16th June 2020

Application No: LU/46/20/PL
Site Address: Littlehampton Covered Market 26-28 Surrey Street Littlehampton BN17 5BG
Description of works: Demolition of existing building & construction of 1 No retail unit & 3 No. flats with associated external works & access. This application affects the setting of listed buildings & may affect the character & appearance of the River Road, Littlehampton Conservation Area.

OWPC27745

Proposed Plans And Elevations

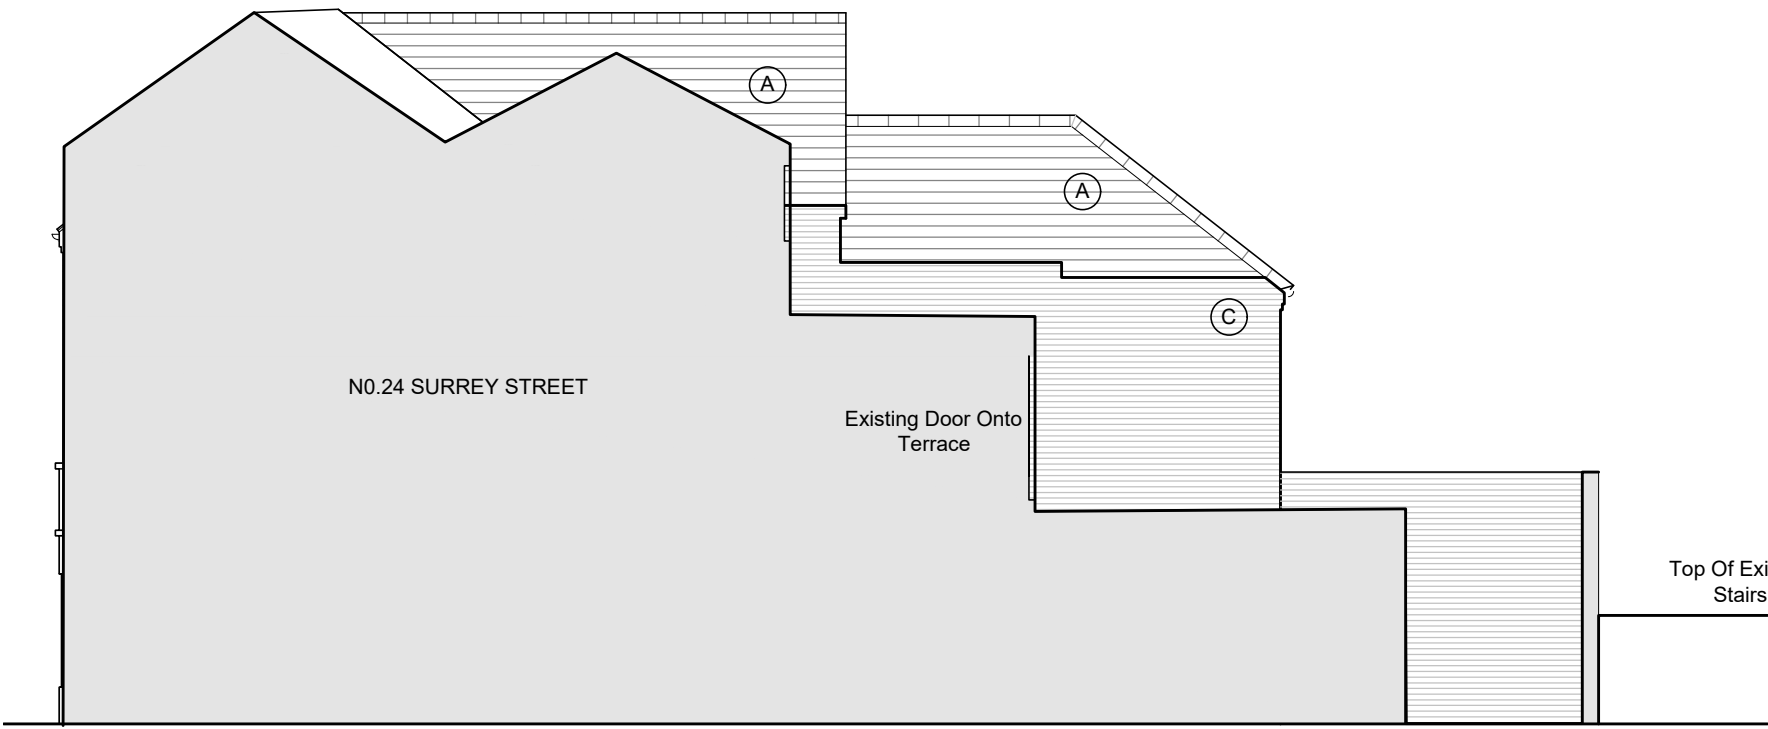
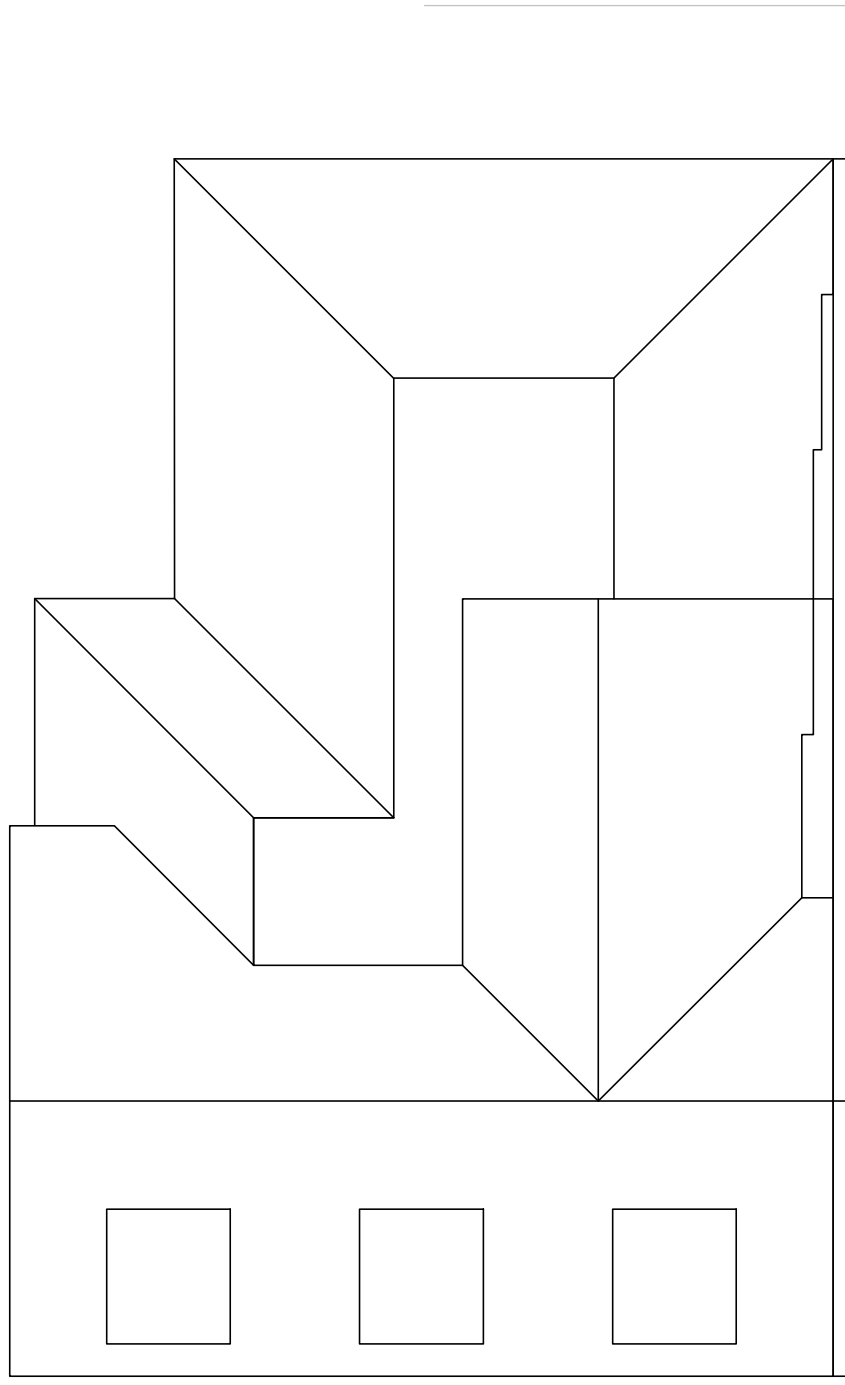
(1) The use of pvcu sash windows, even though they may be 'conservation grade', is simply not satisfactory given the site's location so near to designated heritage assets. As mentioned before they need to be painted timber vertically sliding sash windows in order to protect the setting of nearby listed buildings and the conservation area.

(2) The use of fibre cement slates is also unsatisfactory due to their absolute regularity in shape and propensity over time for their colour to fade and to attract visually unsuitable lichens rather than the attractive patina of natural slates. Natural slates exist on the roofs of the adjoining and nearby listed buildings and the use of fibre cement slates will, again, detract from the setting of these historic buildings and the conservation area. For these reasons, natural slates should be used on the roofs of the proposed development.

(3) There is a mixture of rendered and brick facades in the locality and the use of an appropriately coloured render would make the new building more of a focal point in the street scenes. It also avoids the possibly clumsy appearance of the relationship of a new brick facade immediately abutting the old brick facade of 24 Surrey Street if the brickwork colour, pointing and bond is not quite right. It is considered that render could work well and the introduction of a black painted plinth around the base of the new building would enhance its appearance. If render is to be used then rendered flat splayed arches over the window heads would be more appropriate than the brick segmental arches shown on the plans.

(4) Special care will also be needed to ensure the use of good quality materials and finishes for the dormer windows which will be very prominent features in the street scene.
